Application Ref:	2025/0471			 Ribble Valley Borough Council www.ribblevalley.gov.uk				
Date Inspected:	01/07/25	Site Notice expired:	22/07/25					
Officer:	KH							
DELEGATED ITEM FILE REPORT:					APPROVAL

Development Description:	LBC for repairs and alterations including re-pointing, removal of modern fireplaces and removal of WC compartment.
Site Address/Location:	Holkers Farm, Whins Lane, Read BB12 7RB

Houalker's Farm, Read
First Floor Plan
As Existing

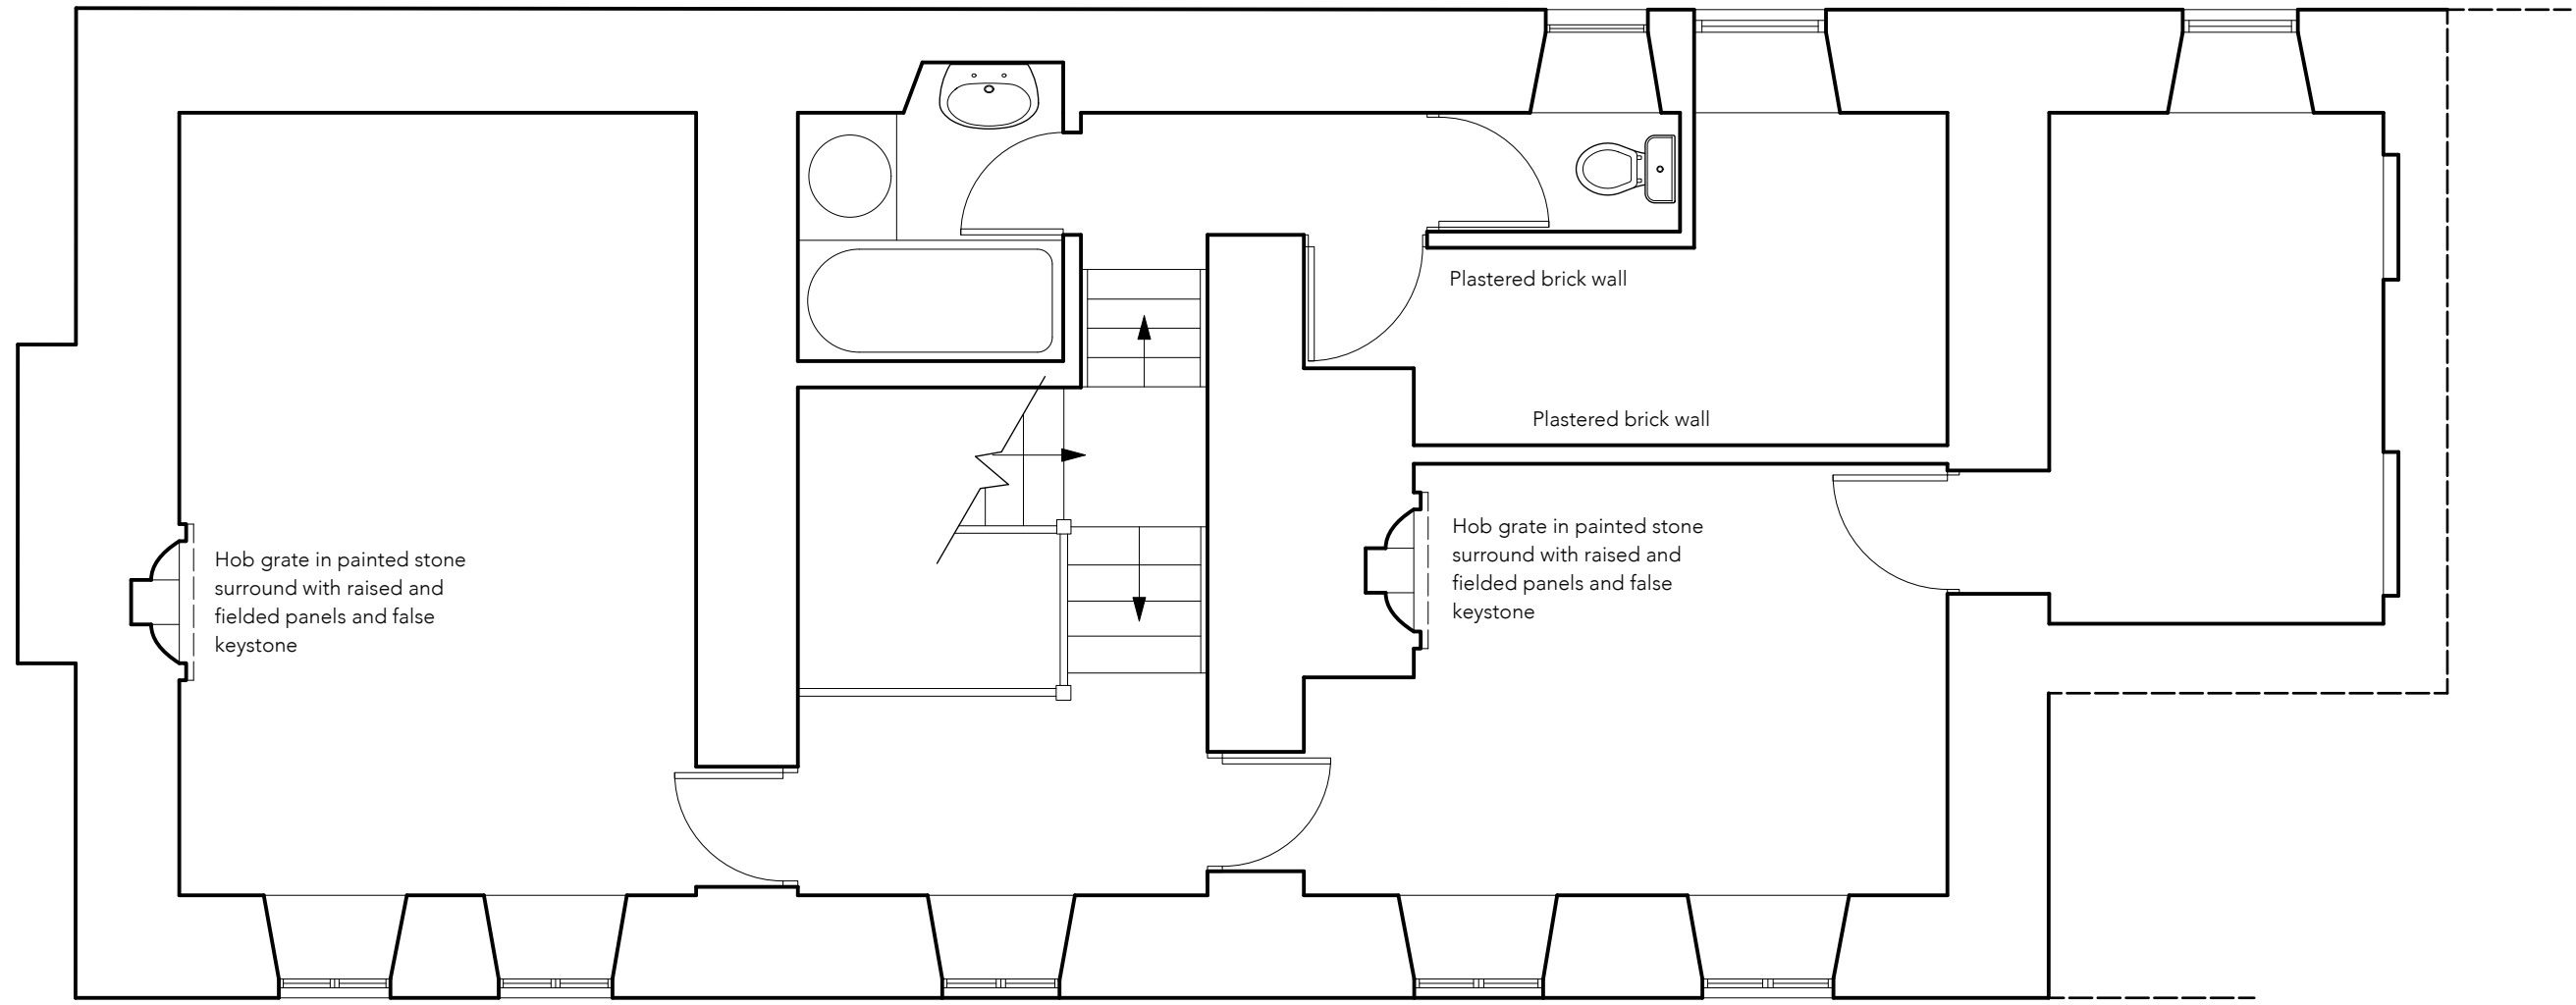
The removal of the WC compartment is a heritage benefit and will restore the room to its intended proportions.
